May 12, 2021

El Paso County Development Services
2880 International Circle Suite 110
Colorado Springs, CO 80910

Letter of Intent

Lamar Advertising is requesting Special Use approval to install a billboard.

**PLOT PLAN/ SPECIAL USE MAP**  
 A PORTION OF THE NE1/4 OF SECTION 7,  
 TOWNSHIP 13 SOUTH, RANGE 65 WEST OF THE SIXTH P.M.,  
 CITY OF COLORADO SPRINGS, EL PASO COUNTY, COLORADO

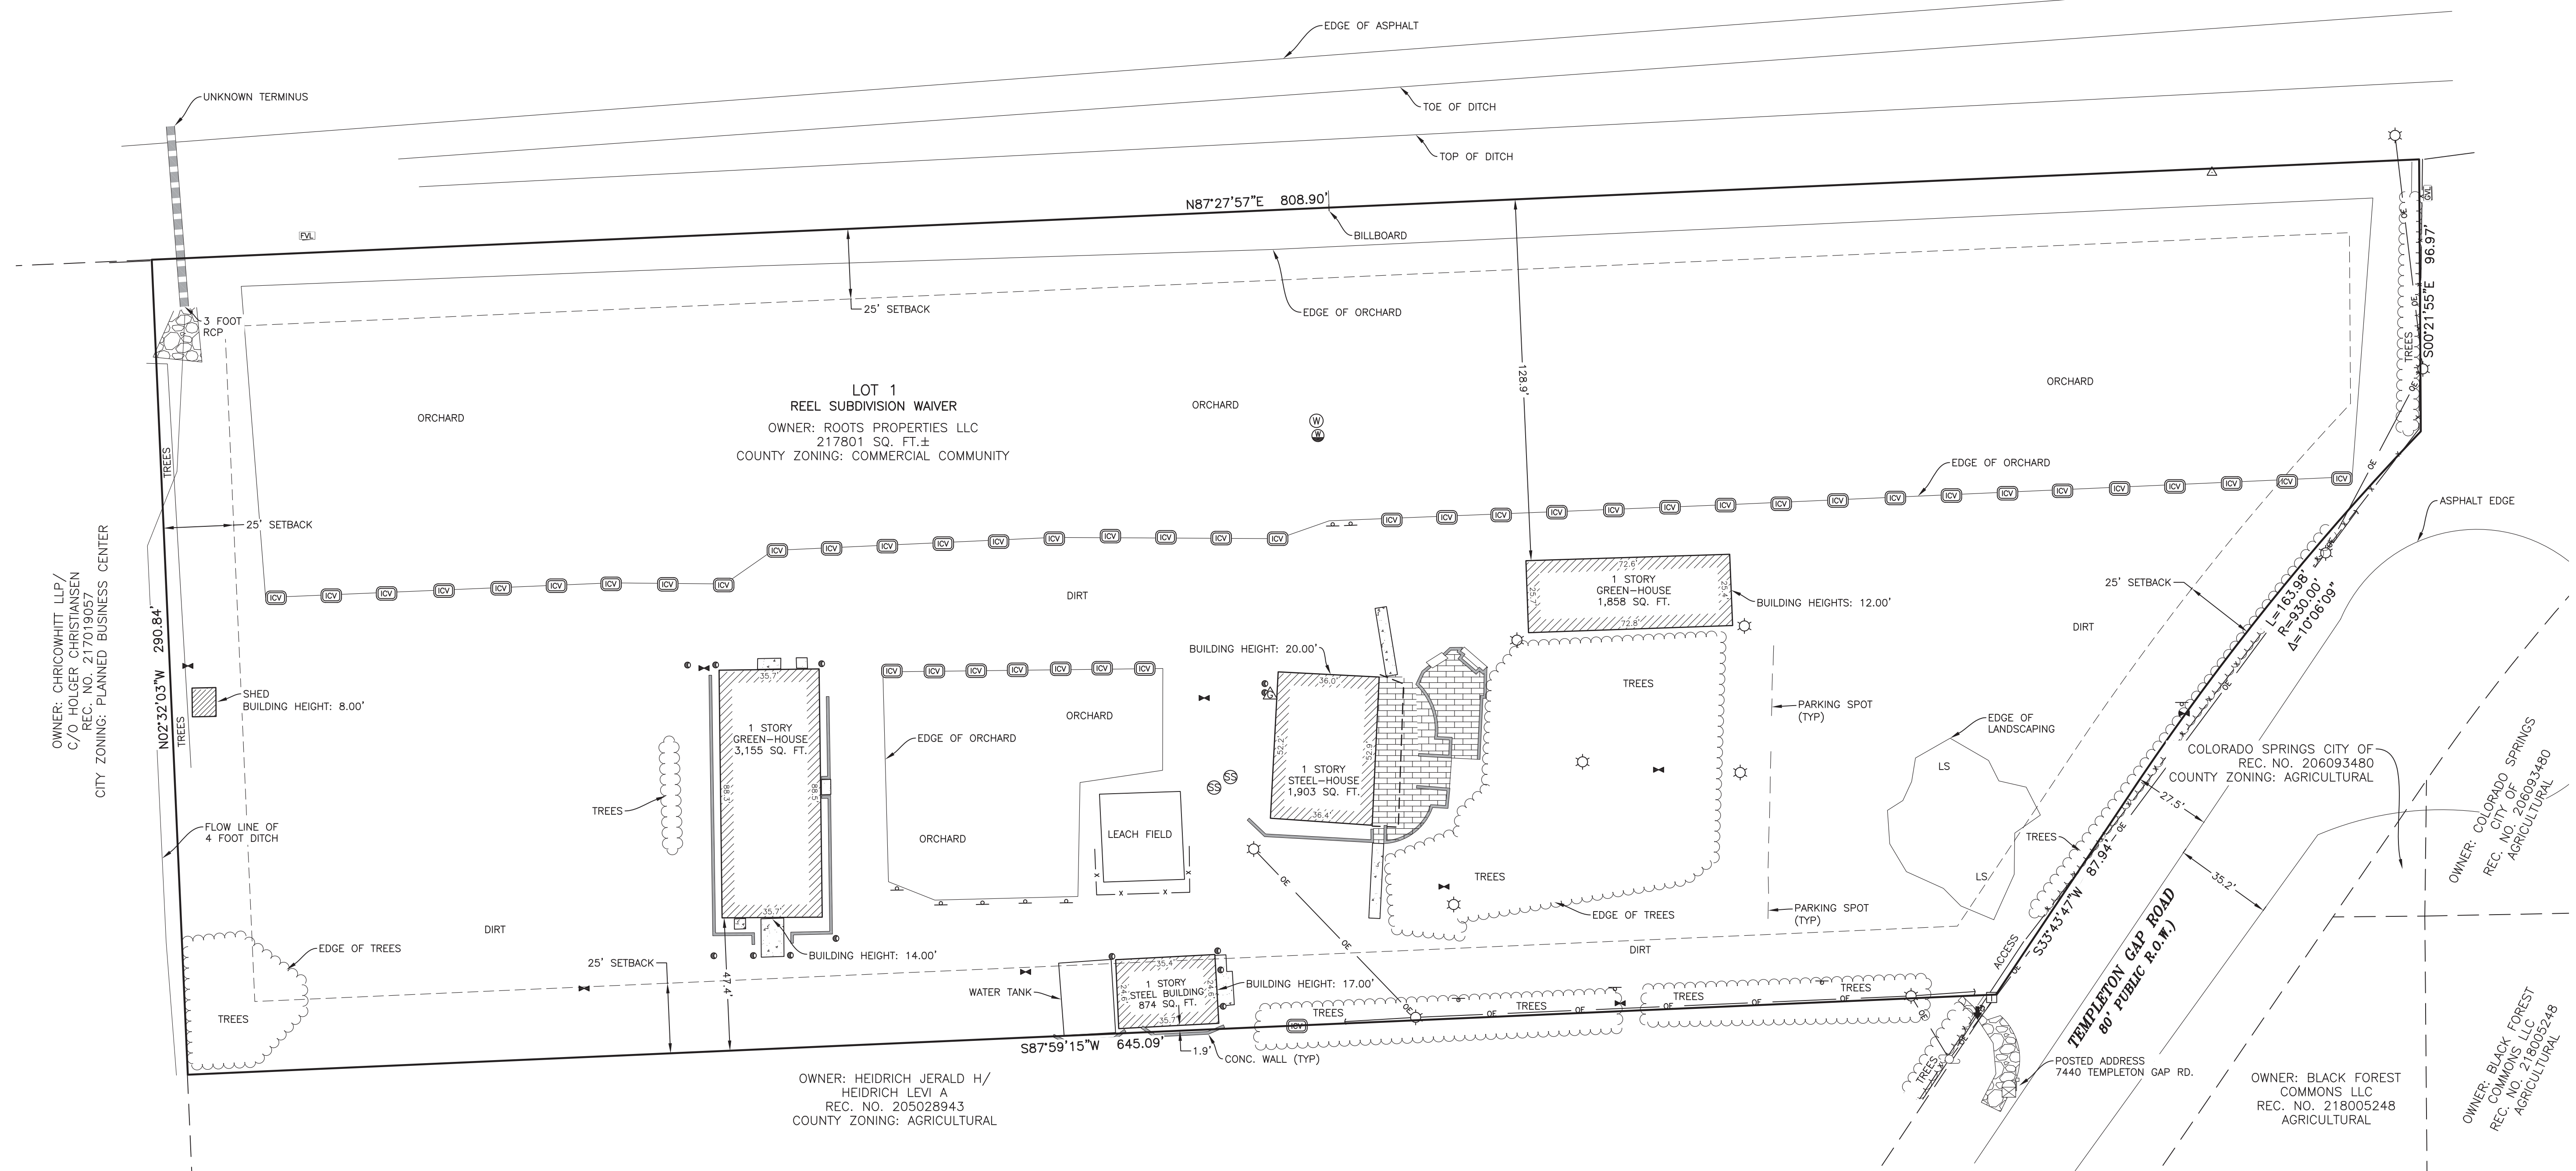
LDC Sec. 6.2.9(B)(4) - setbacks and location standards. Provide justification that the criteria is being met with the request.

Light Analysis for DB 10'6" x 36'

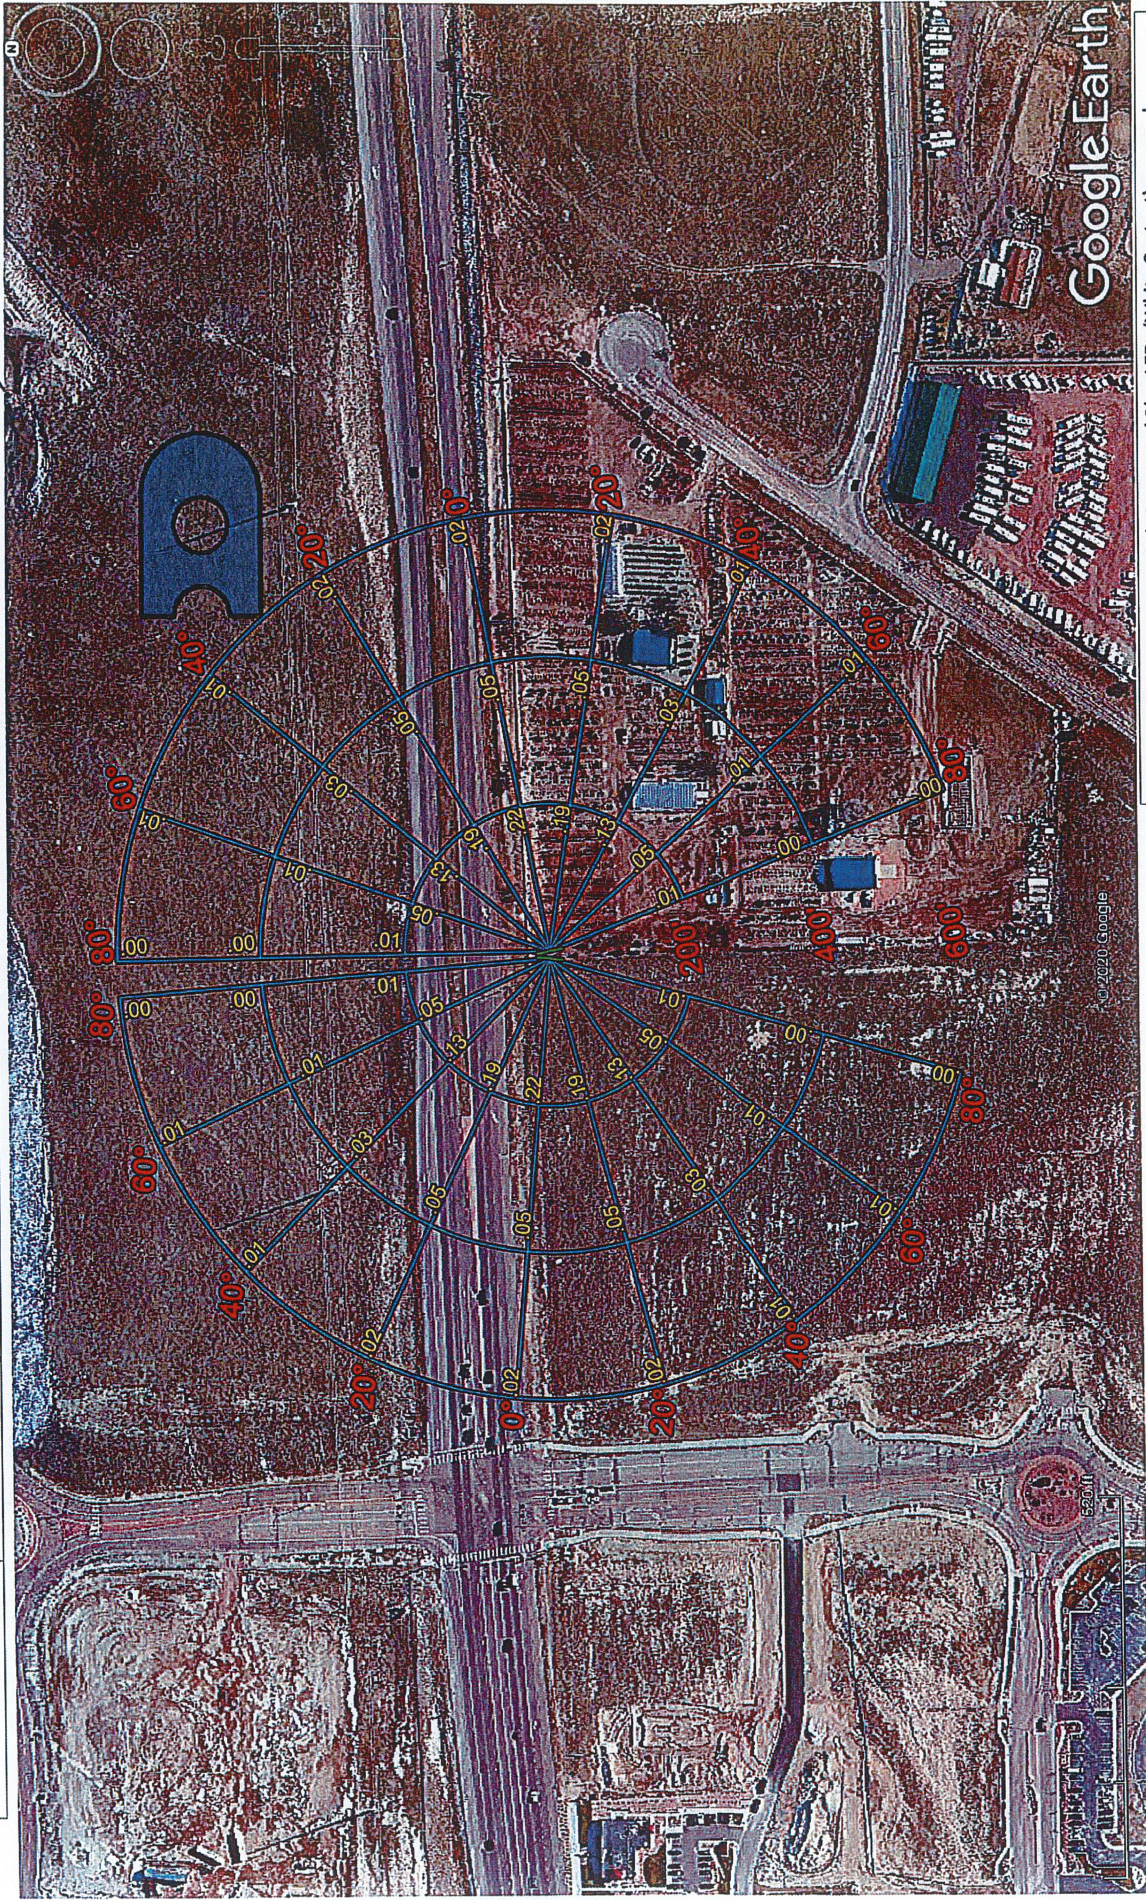
- *The special use will comply with all applicable local, state, and federal laws and regulation regarding air, water, light or noise pollution:* This billboard structure emits no air pollution, requires no water, and does not make noise. The light intensity is monitored by electronic sensors that dim the display. **The lighting plan that was provided shows extensive light spillage onto adjacent properties. See below for more information.**
